Consultation Response from KC, Highways Development Management (HDM)
2025/92541 Land off, Roslyn Avenue, Netherton, Huddersfield, HD4 7EW
Operational development to create development plateau comprising land level changes, highways construction, utilities diversions and drainage construction
Date Responded: 11/06/26
Responding Officer: A Darwin
Responding Ref: K3-24/14

RECOMMENDATION: No objection, subject to conditions
--

CLIENT	KCS DEVELOPMENT LTD		
CHECKED	APPROVED	DRG No.	
PMO	PMO	23046/GA/01	
DRAWN BY:	SCALE @ A3	DATE	REV.
RP	1:250	AUGUST 2023	-

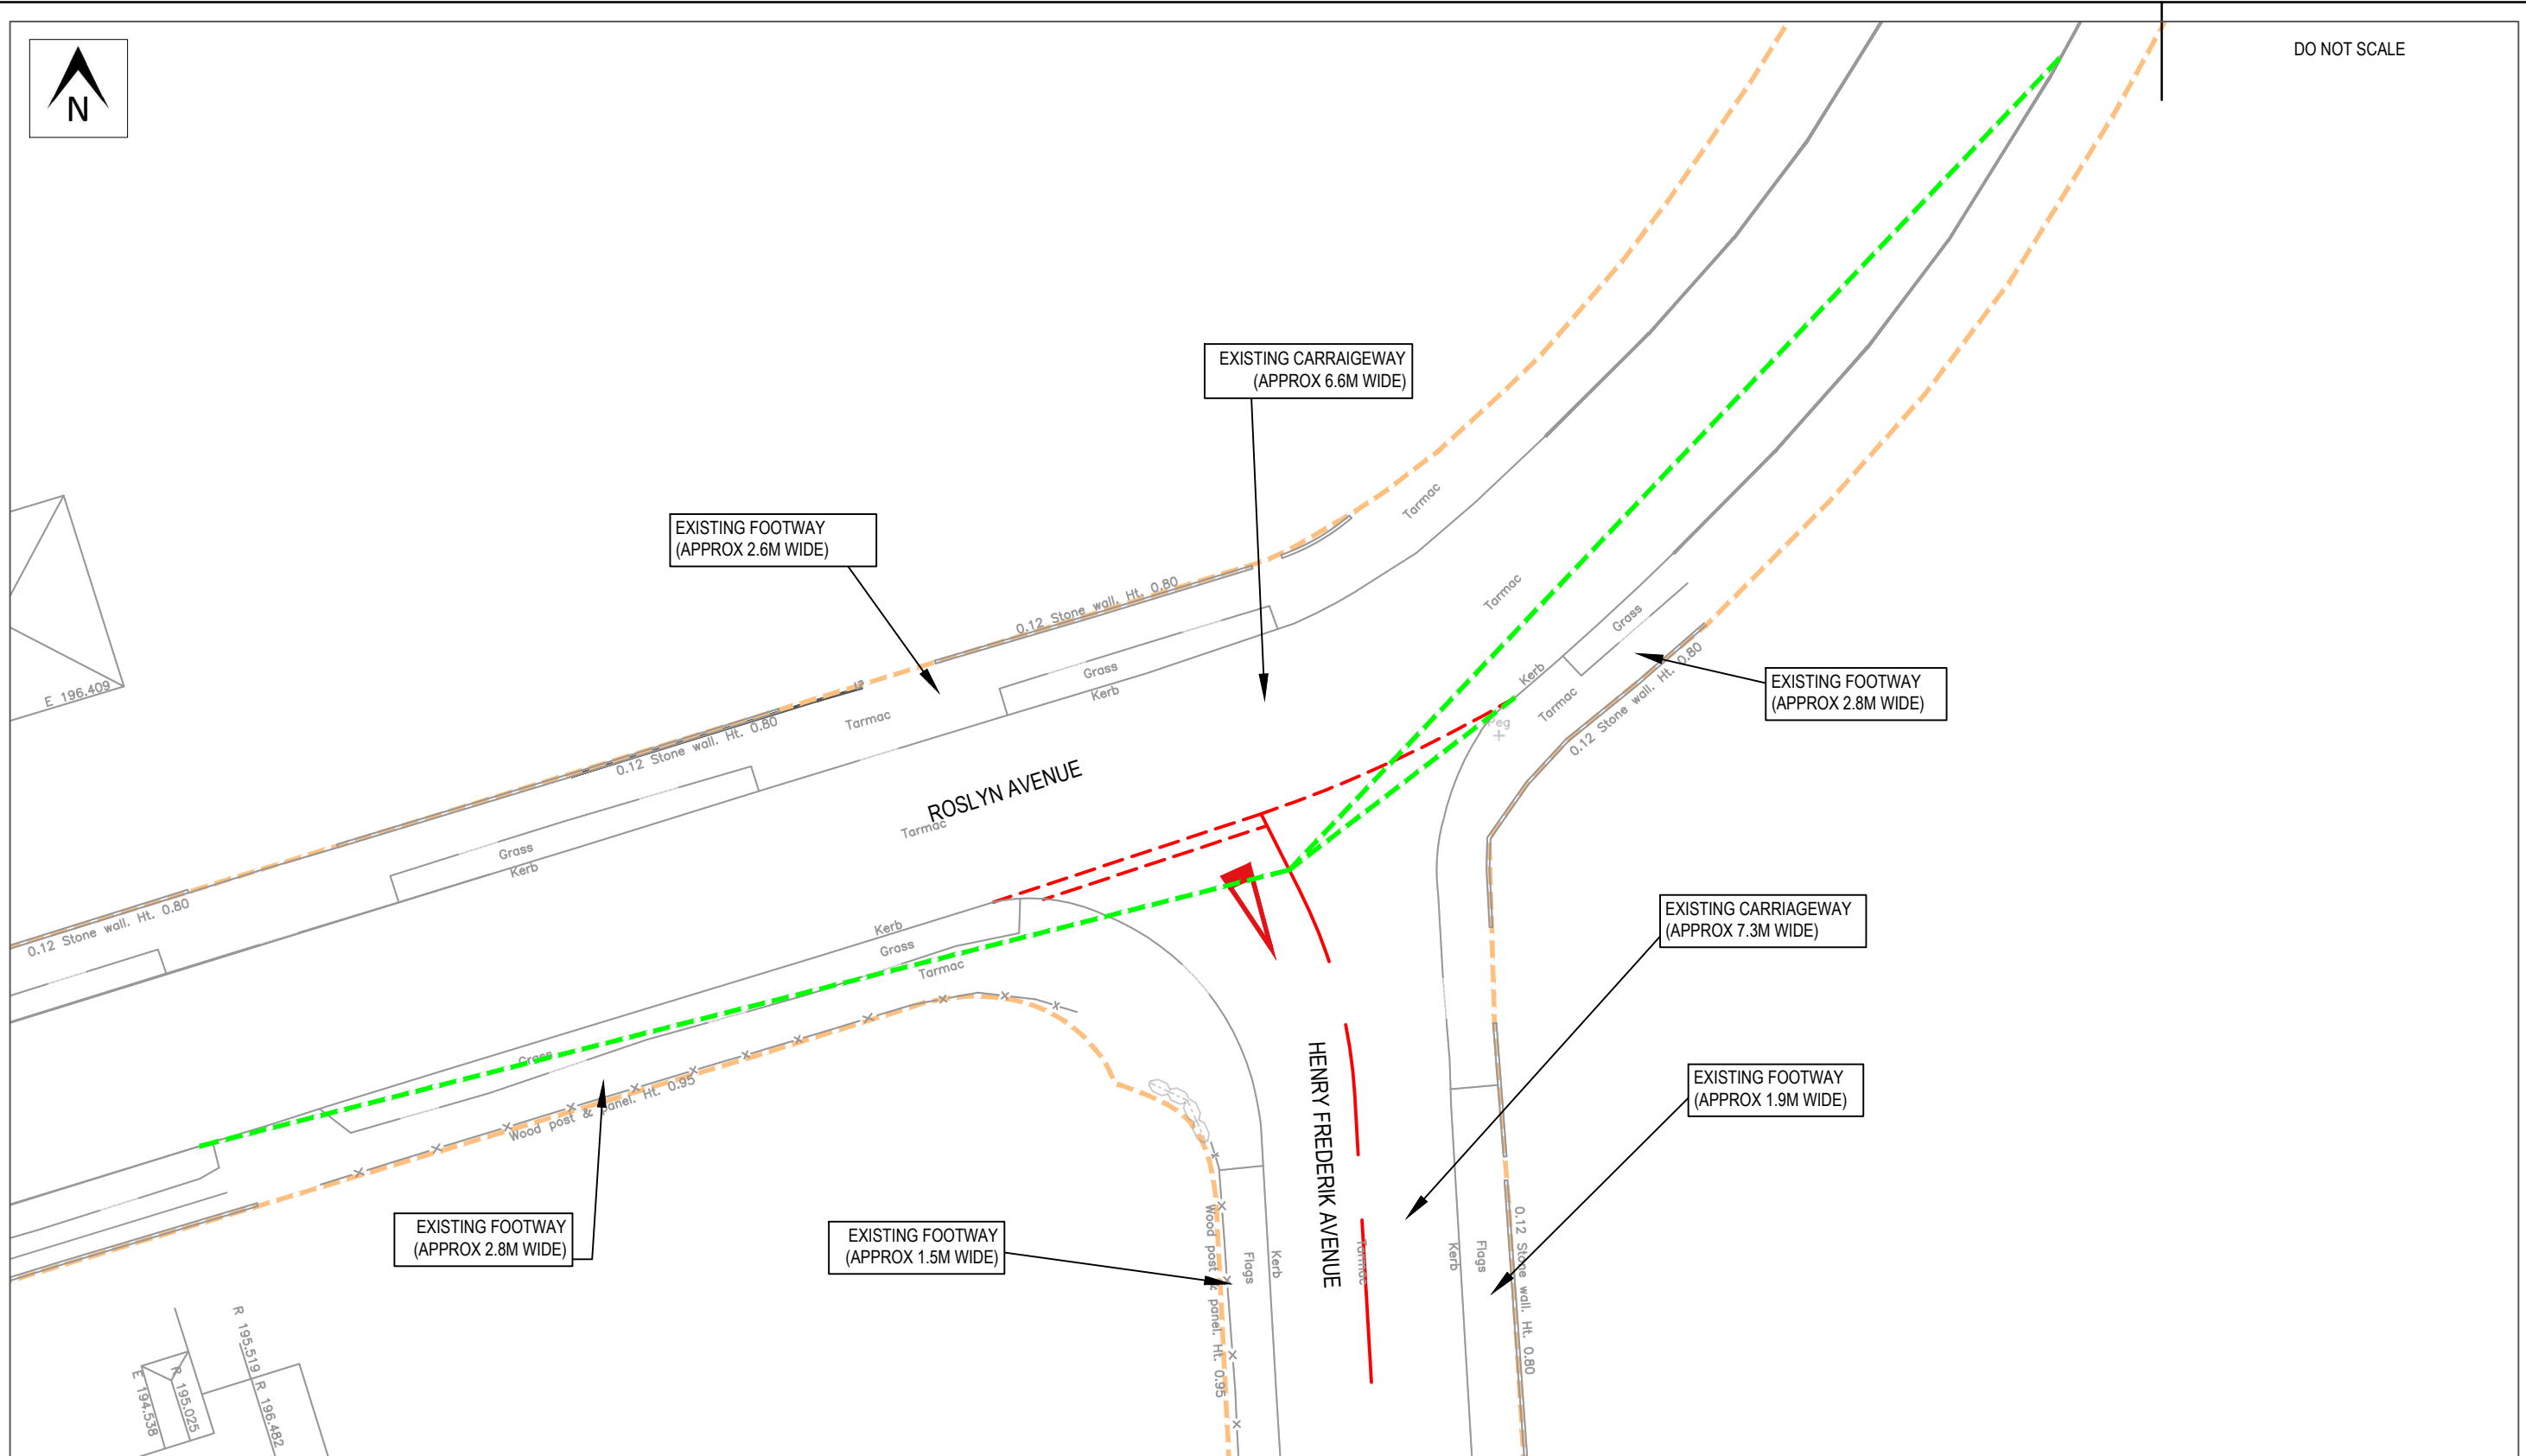
- Condition 31 (Internal street details and phasing).
- Condition 32 (Site access and off-site highway works details) – Condition to be reworded to reflect submission information (e.g. reference to amended plan EE100008-301 P7 and 23046/GA/01 that was omitted from previous condition and is required for clarity of the proposed road marking works).
